WEST SUSSEX COUNTY COUNCIL CONSULTATION

TO:	Arun District Council FAO:Michael Eastham
FROM:	Stephen Gee WSCC - Highways Authority
DATE:	22 September 2021
LOCATION:	Land East of Tye Lane Walberton BN18 0LU
SUBJECT:	WA/63/21/PL Proposed alternative vehicular accesses off Tye Lane and emergency access off Avisford Park Road, along with minor highway works following WA/95/18/RES (resubmission following WA/93/20/PL). This site is CIL Zone 2 (Zero Rated) as other development.
DATE OF SITE VISIT:	n/a
RECOMMENDATION:	No Objection
S106 CONTRIBUTION TOTAL:	n/a

A1 Scale	Date	Designed by
1:500	DEC 2020	KI
Drawn by	Checked by	Approved by
KI	KI	KM
Drawing Number	183248-003	
Rev	C

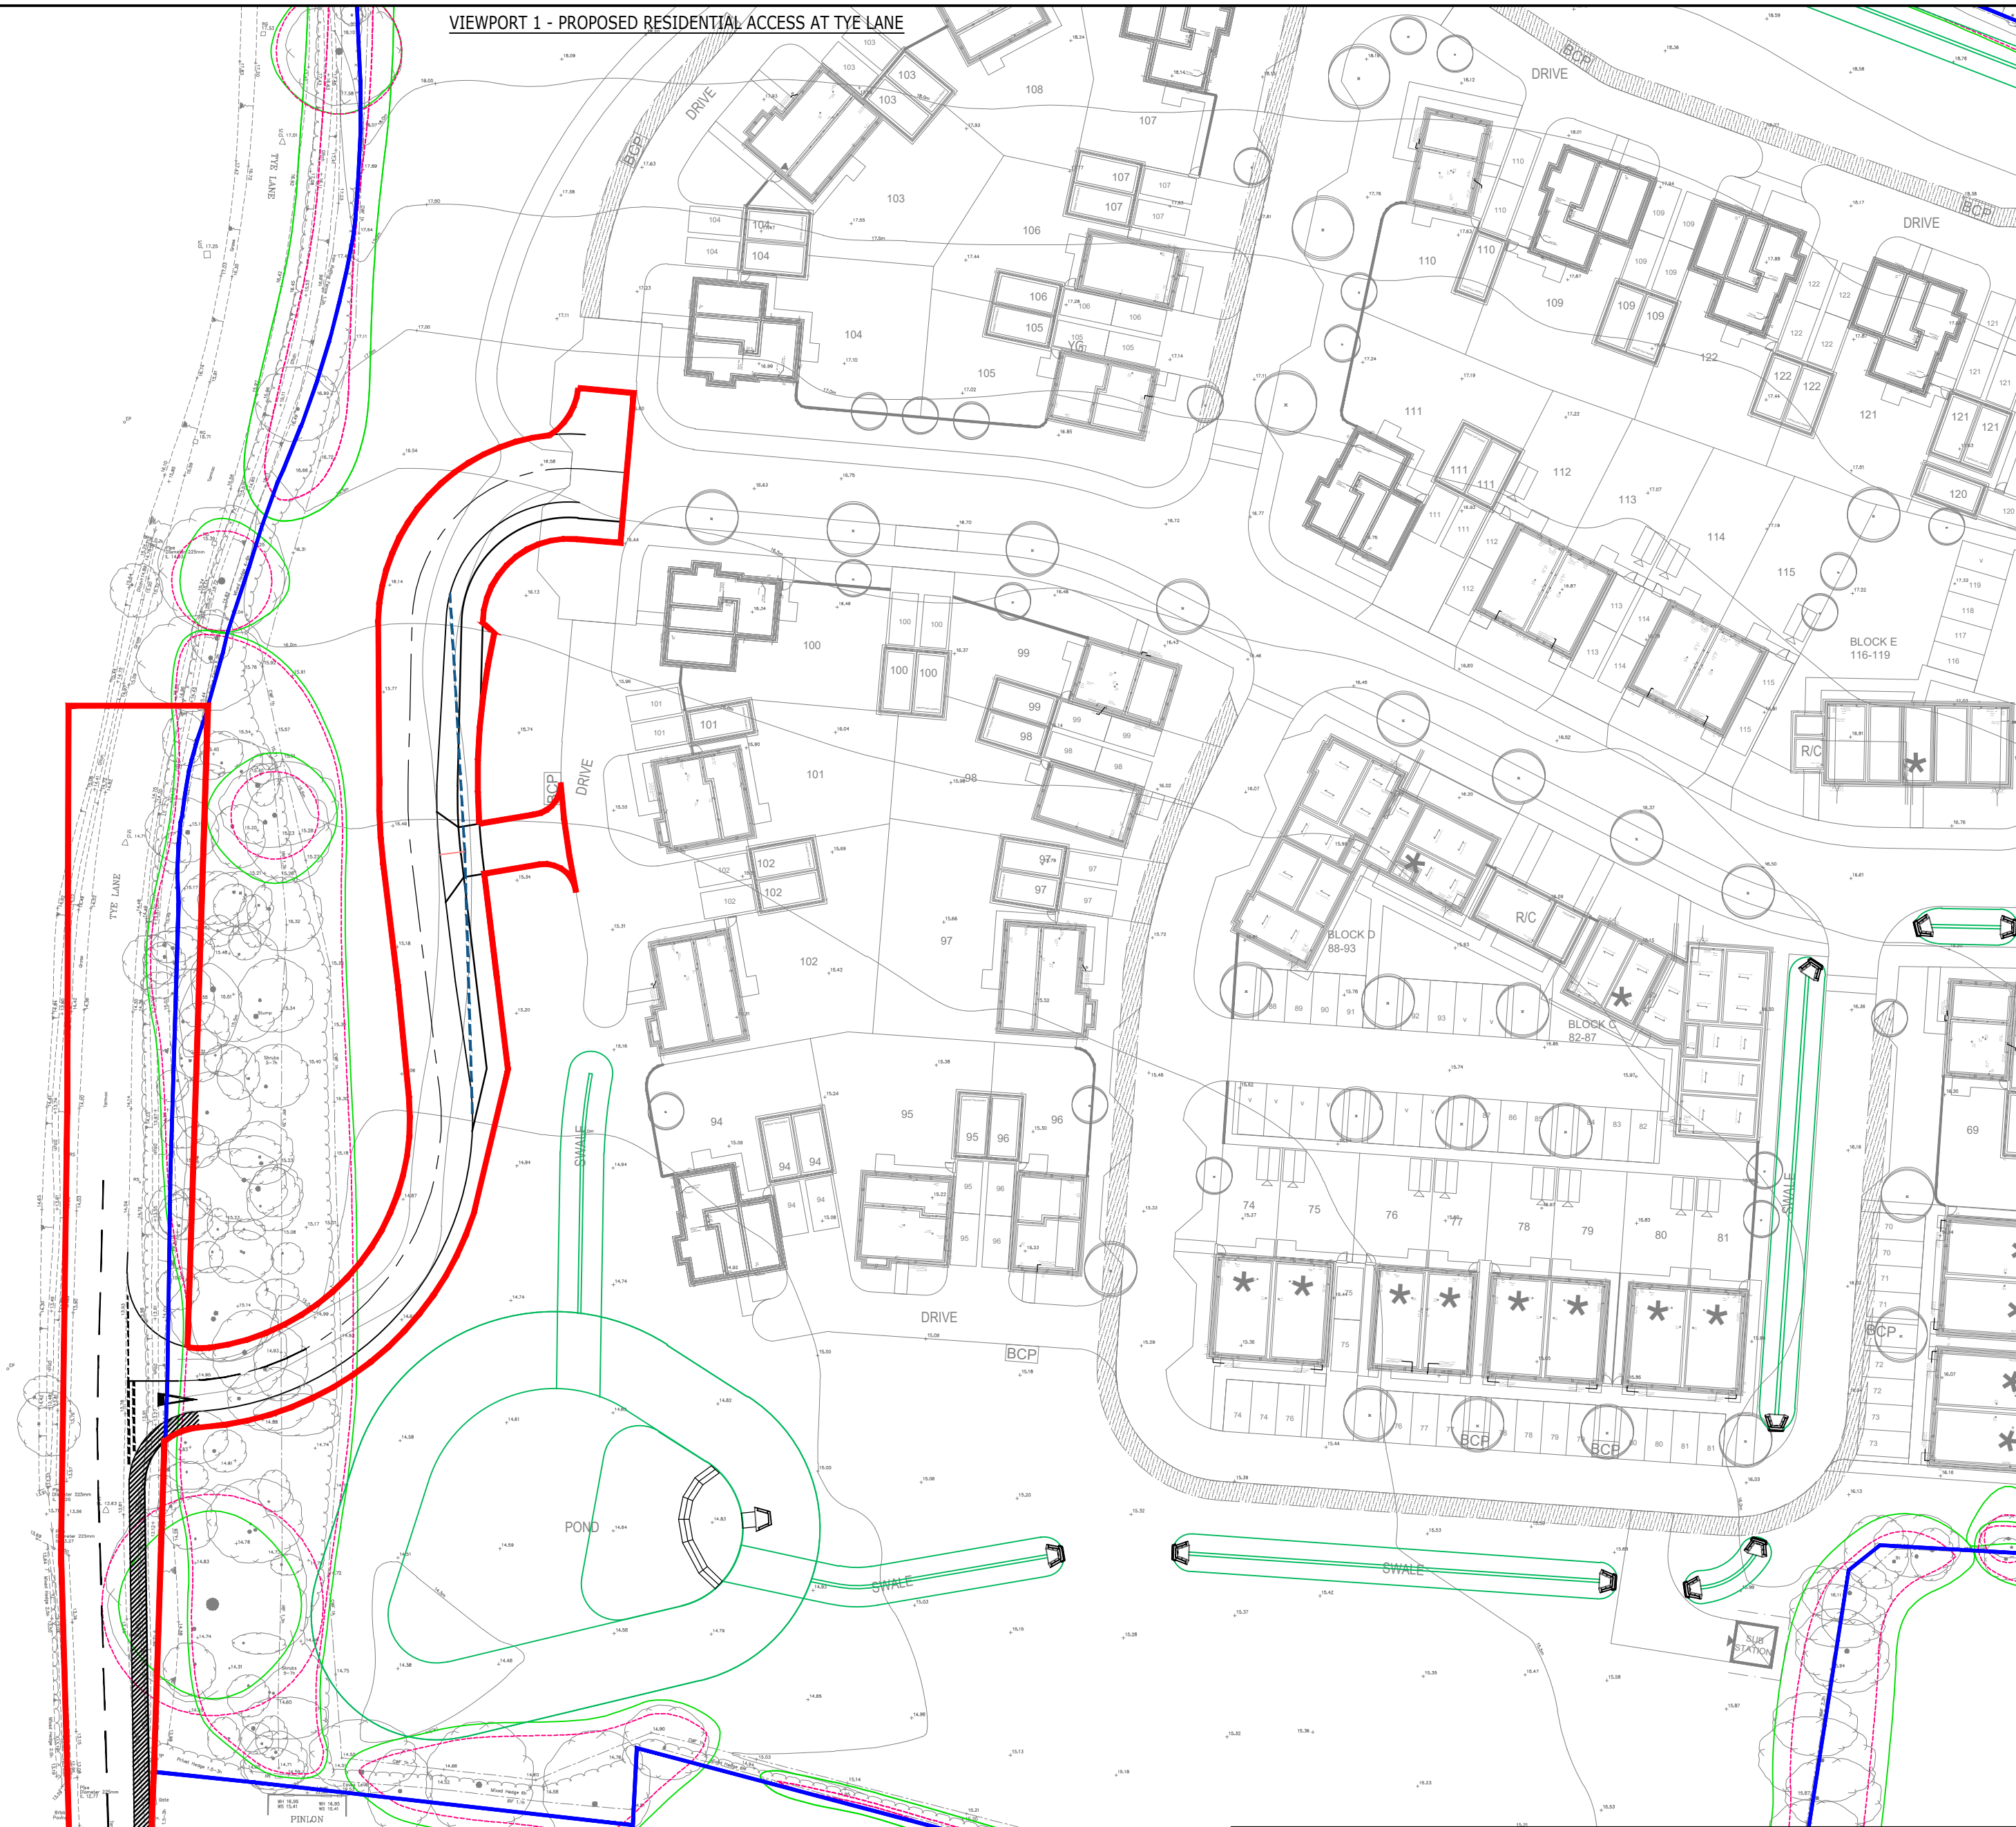
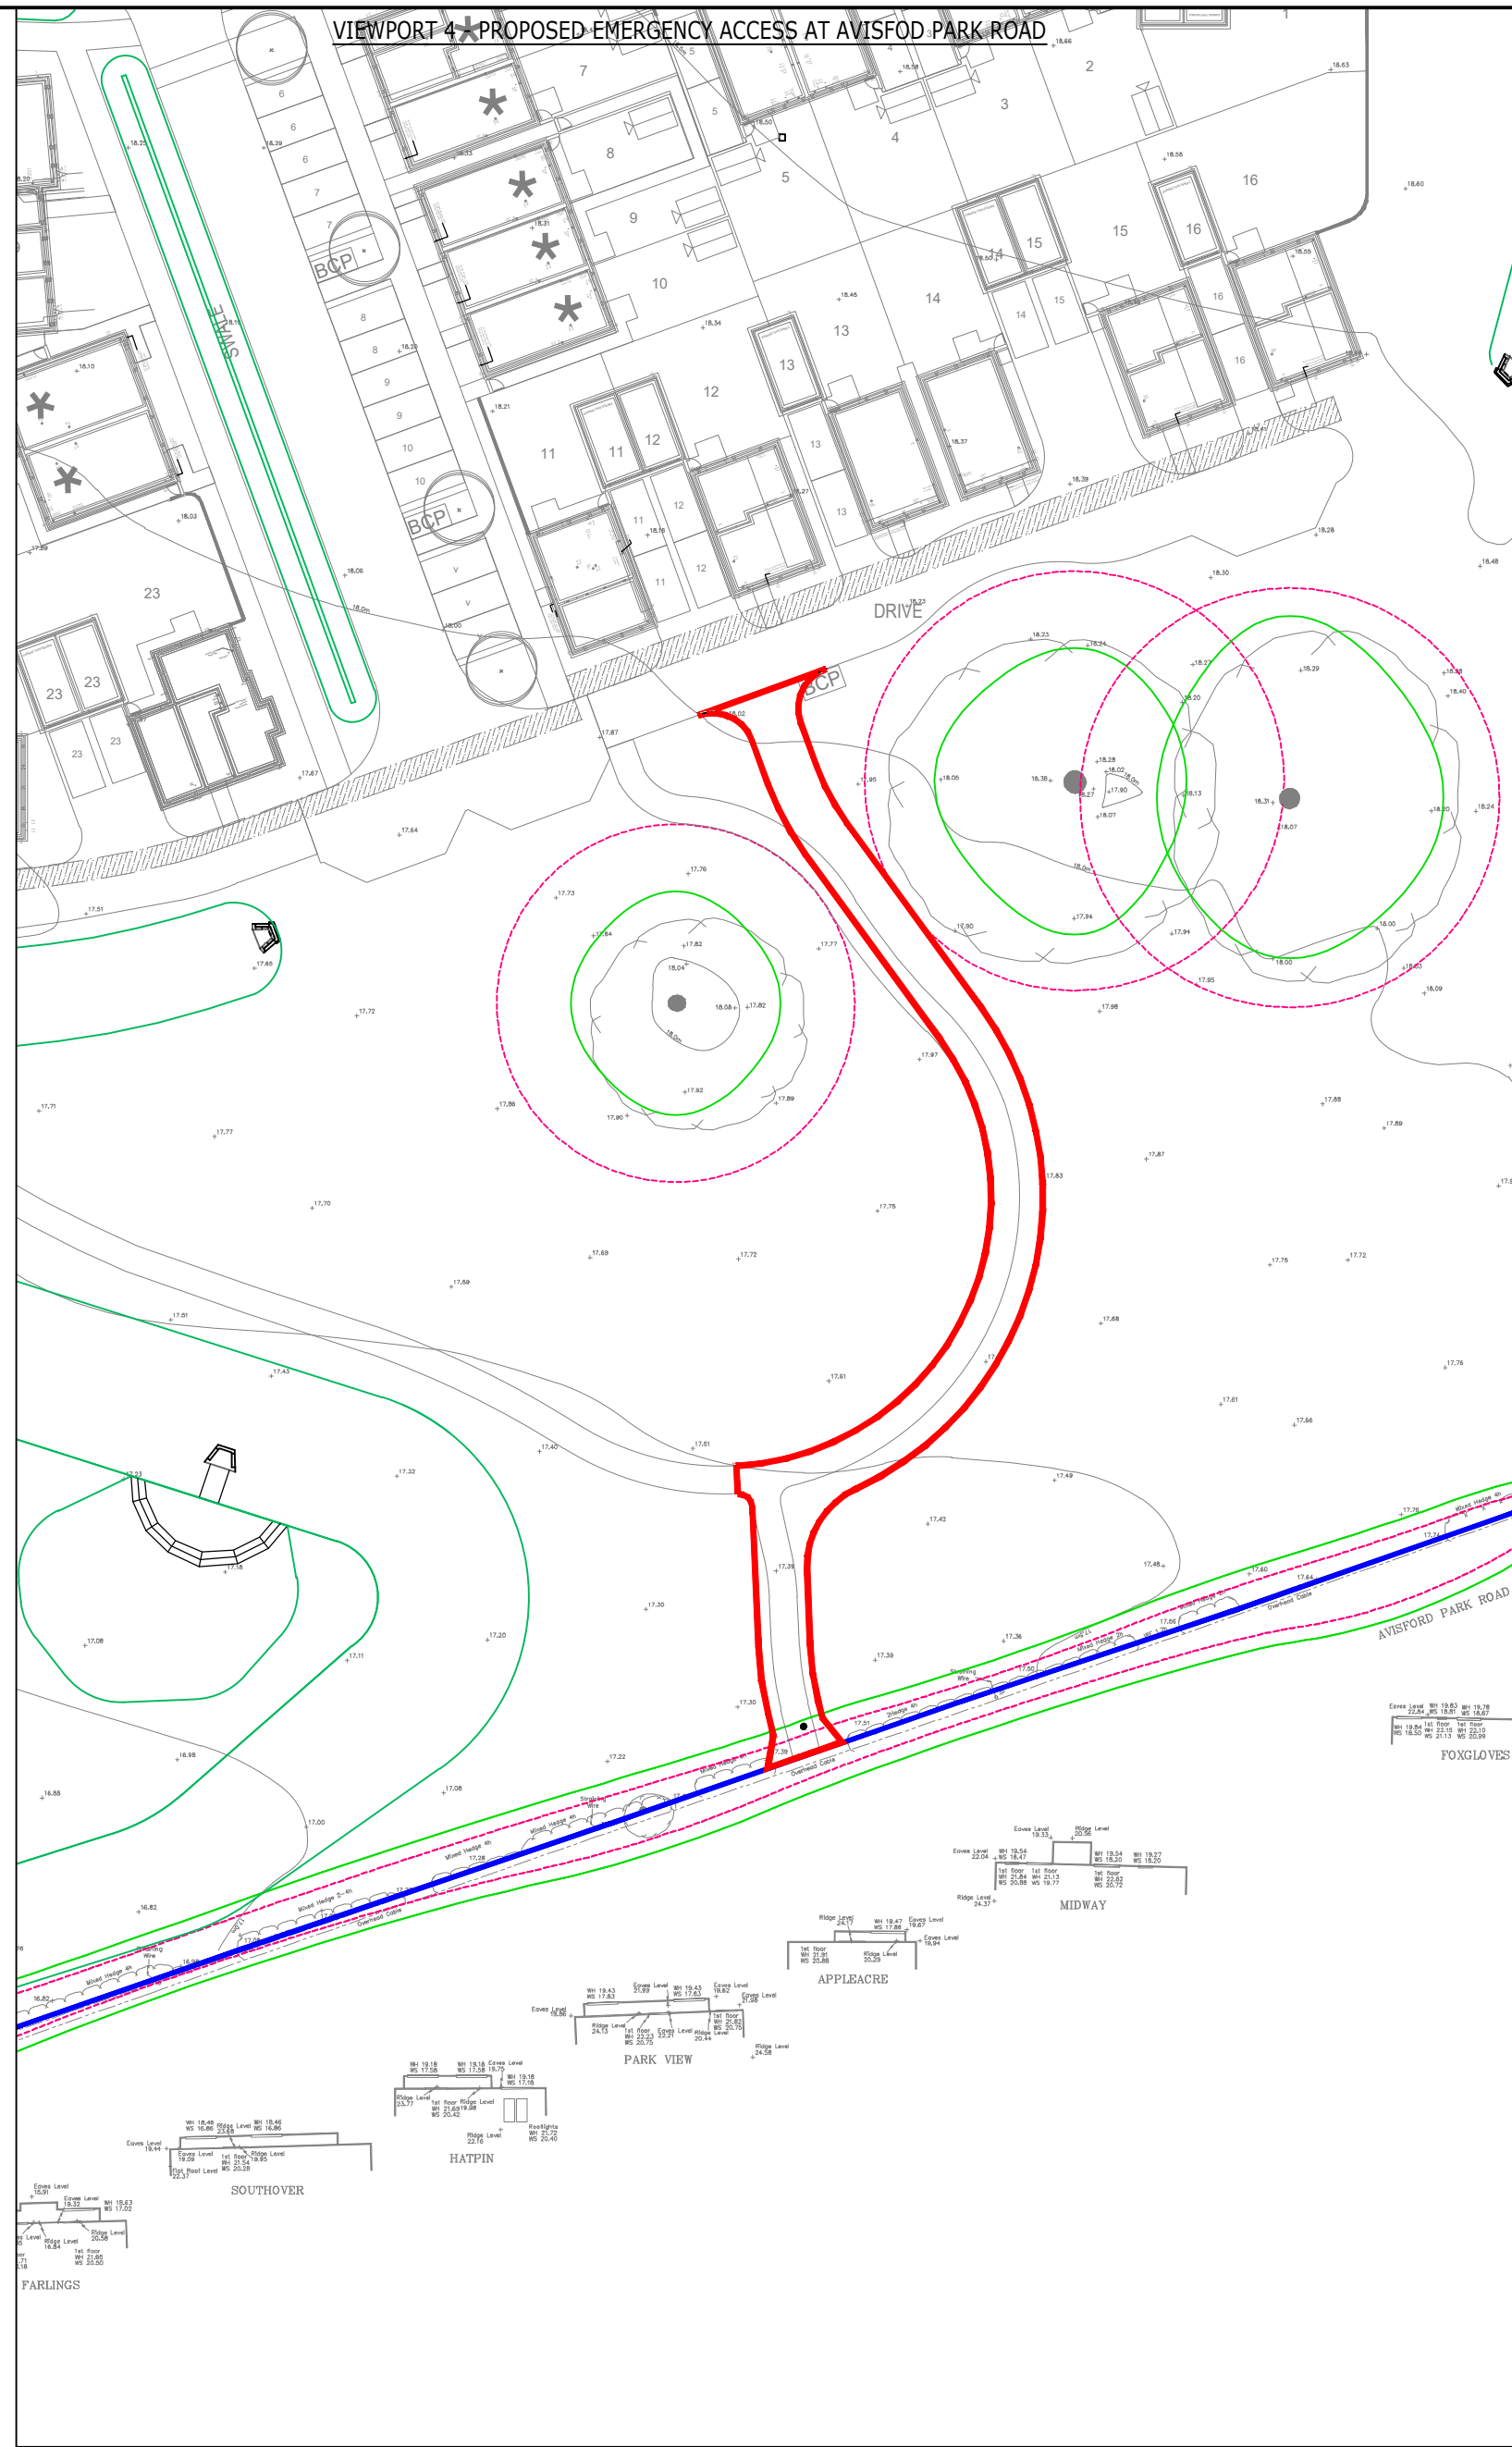
As no assessment has taken place of having both accesses open at the same time and its impact on redistributing vehicles, conditions are requested upon the timescale for closure of the existing access on Yapton Lane and details of the closure. It is felt that the site permeability would benefit from the retention of a walking and cycling route.

Timescale for closure and plans of closure of Yapton Road access – ped/cycle access should be retained

Access Drawing number 183248-002/003 PROPOSED Alternative Access (including pedestrian improvements to Tye Lane)
